# City of Portland, Maine – Building or Use Permit Application 389 Congress Street, 04101, Tel: (207) 874-8703, FAX: 874-8716

Location of Construction: <b>182 Commercial St</b>		Owner: <b>Dinillo, Antonio</b>		Phone: <b>773-7632</b>		Permit No: <b>980737</b>	
Owner Address: <b>25 Long Wharf Portland, ME 04101</b>		Lessee/Buyer's Name:		Phone:		Business Name:	
Contractor Name: <b>Bailey Sign Co.</b>		Address: <b>9 Thomas Dr Westbrook, ME 04092</b>		Phone: <b>774-2843</b>		Permit Issued: <b>JUL - 8 1998</b>	
Past Use: <b>Retail</b>		Proposed Use:		COST OF WORK: \$		PERMIT FEE: \$ <b>774-2843</b>	
				FIRE DEPT. <input type="checkbox"/> Approved <input type="checkbox"/> Denied		INSPECTION: Use Group: Type:	
				Signature:		Signature:	
Proposed Project Description: <b>Erect Signage</b>				PEDESTRIAN ACTIVITIES DISTRICT (P.A.D.) Action: <input type="checkbox"/> Approved <input type="checkbox"/> Approved with Conditions <input type="checkbox"/> Denied		Zone: CBL: <b>030-W-001</b>	
Permit Taken By: <b>MC</b>		Date Applied For: <b>25 June 1998</b>				Zoning Approval:

## BUILDING PERMIT REPORT

DATE: 7 July 98 ADDRESS: 182 Commercial ST. (Ø3Ø-H-ØØ1)  
REASON FOR PERMIT: Signage  
BUILDING

03816 C R3

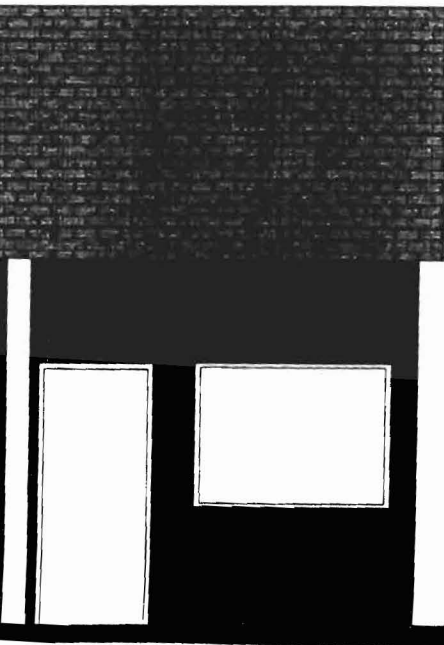
- ✓ 31. *ONCP More your application need a fastening detail on how sign will be attached - Please submit this before ~~submitting~~ sign off.*
